15 December 2021

Sydney Football Stadium – Precinct Village and Car Park Project (SSD 9835 MOD 7)

Response to Submissions | Transport Assessment

Figure 1 Extent of updated traffic model

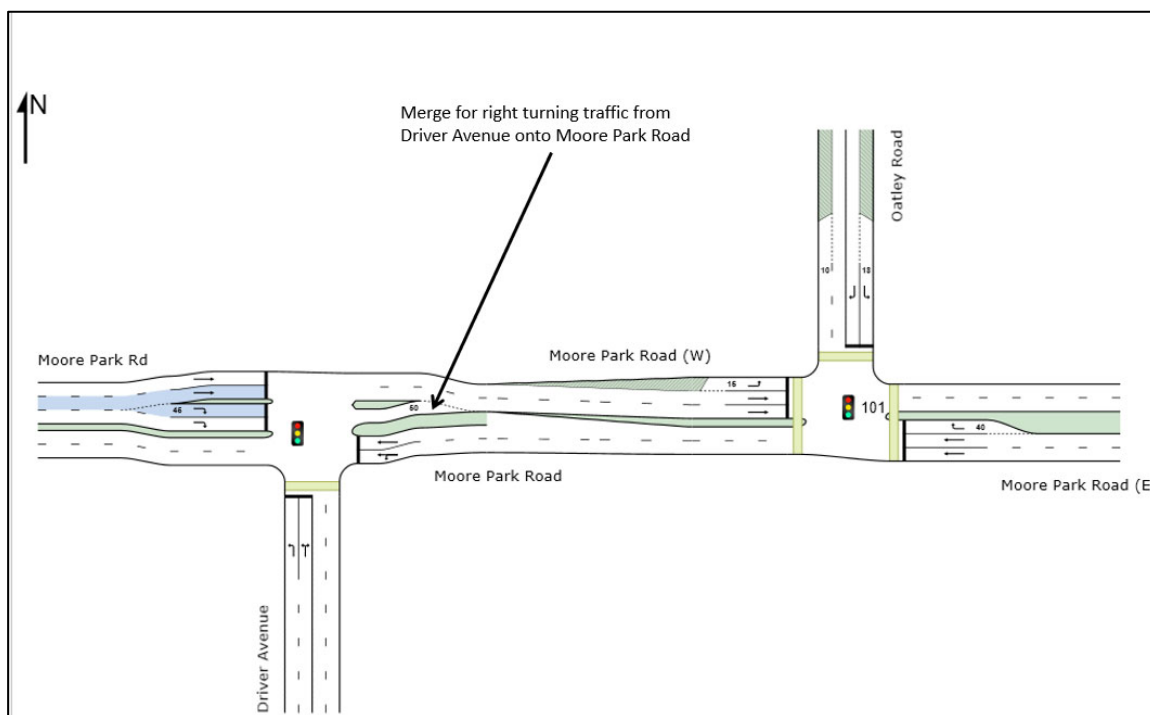
Council also raised the following concern in its submission *“It appears the signalised intersection has been modelled in isolation rather than modelling two sites including the traffic signals and the merge of the right turn into general traffic eastbound on Moore Park Road and connected as a network. If this modelling is incorrect, and it appears to be, consideration must be made to limiting the number of spaces available outside of stadium events.”*
